City of Albuquerque Stormwater Construction Site Inspection Report

ESC File No.	Q16EA5000A	Project Name:	Kairos Power
NPDES Id. No.	NMR10033B/NMR1004XE	Location:	5201 Hawking Dr. SE
8/23/2022	Owner? - NMR10033B	NMR1004XE	
Operator	Kairos Power, LLC	Kairos Power, LLC	
Contact name & title	Lance Hagenbuch	Lara Gutierrez	
e-mail	hagenbuch@kairospower.com	gutierrez@kairospower.com	
Contact Phone #	510-230-3353	510-808-5265	
COA Inspector	Doug Hughes	Start/End Time:	11am
Construction Phase:	Stabilization		
Type of Inspection:	Regular	Storm Event	Past Storm Event >0.25"
		311/Complaint	Follow Up
Weather at time of inspection?	clear	Temperature:	~ 80
Estimated date of last storm 0.25" or greater	8/21/2022

ESCP 1

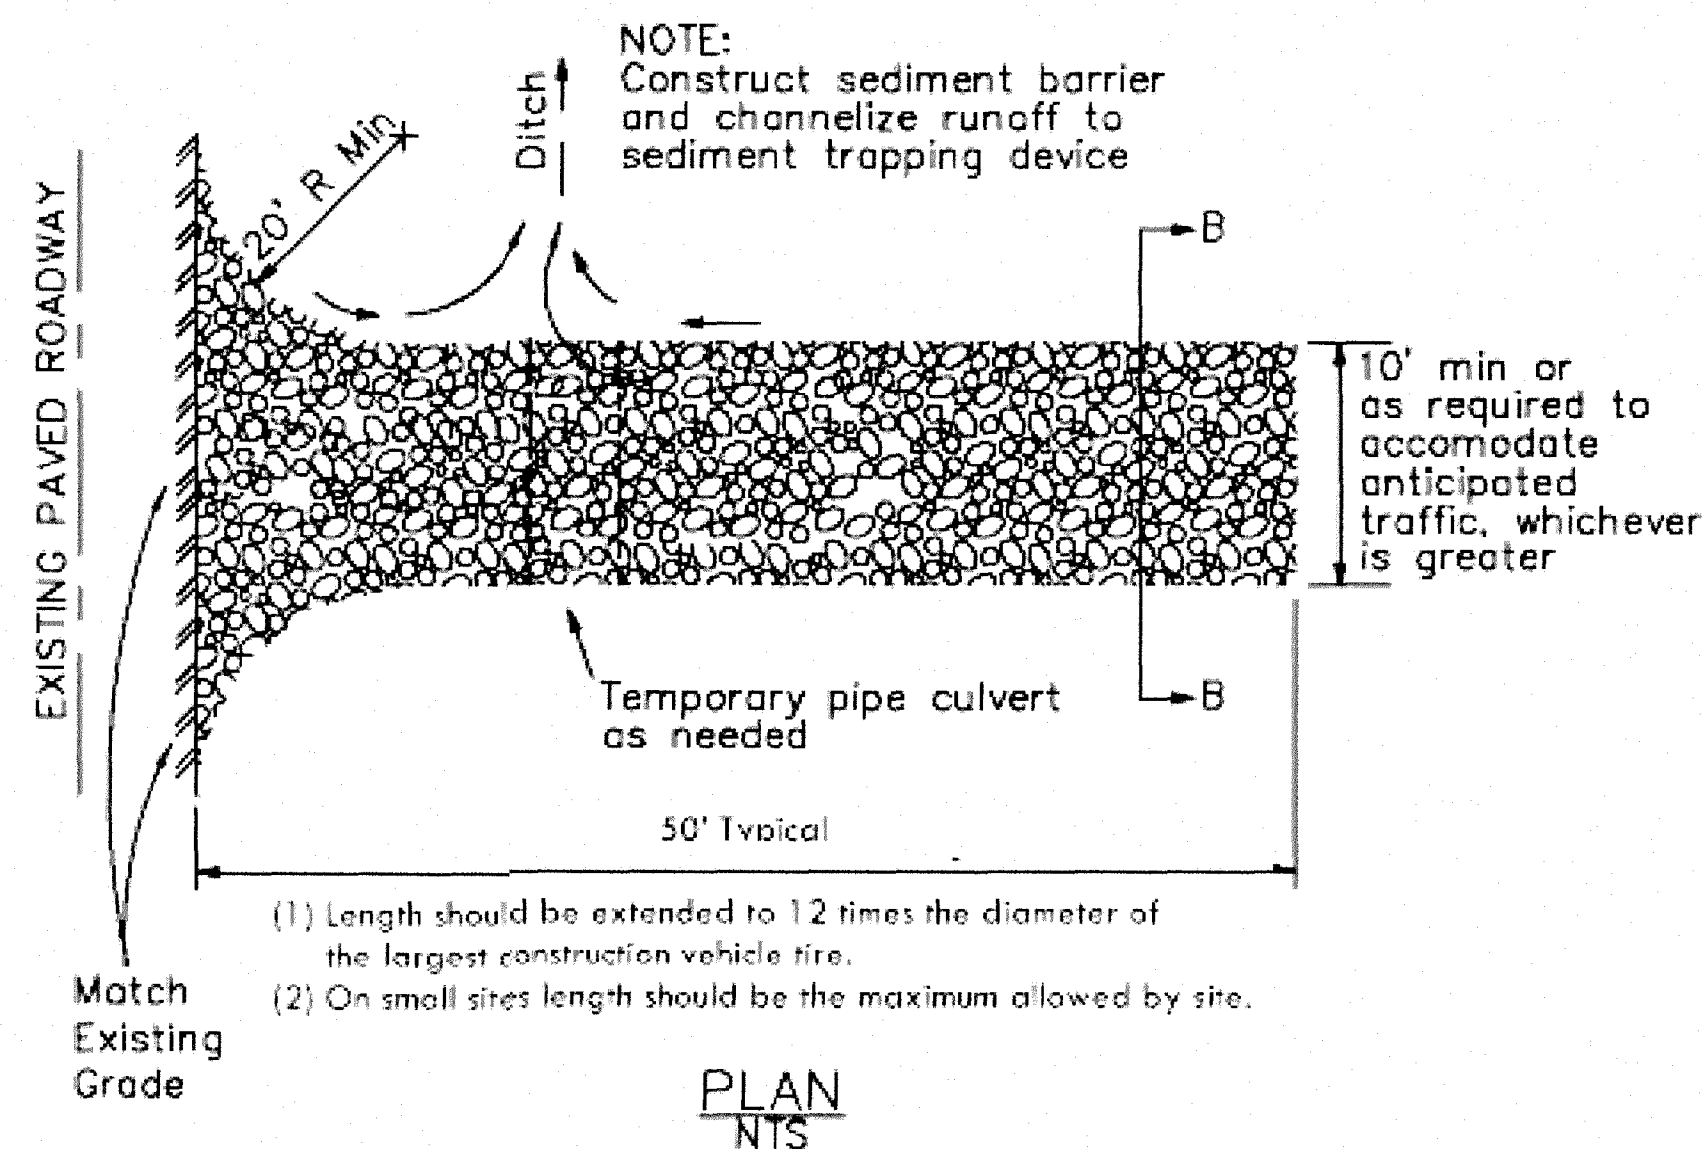
Item Number	Deficiency/ Corrective Action		
1	Posting of permit coverage was missing. Post signage of NOI permit coverage in a location clearly visible to the public CGP1.5.		
2	The up-to-date SWPPP was not available onsite. The SWPPP must include current self-inspection reports and an accurate SWPPP map showing current BMPs and current area of disturbance per CGP 7.2.1 and 7.2.4.		
3	Permit coverage lapsed from termination of NMR10033B on 2/18/2022 to issuance of new coverage NMR1004XE effective on 7/22/2022. Termination was certified by Estefanita Maestas of stormwatersolutionsllc4@gmail.com. Provide explanation for lapse in coverage, missing inspections, and delay in stabilization.		
4	Inactive areas must be stabilized within 14 days per CGP2.2.14.		
2.1	Discharge off site? (Y/N)	no	
4	Self Inspection Reports	Requested	Latest report Date: None on file
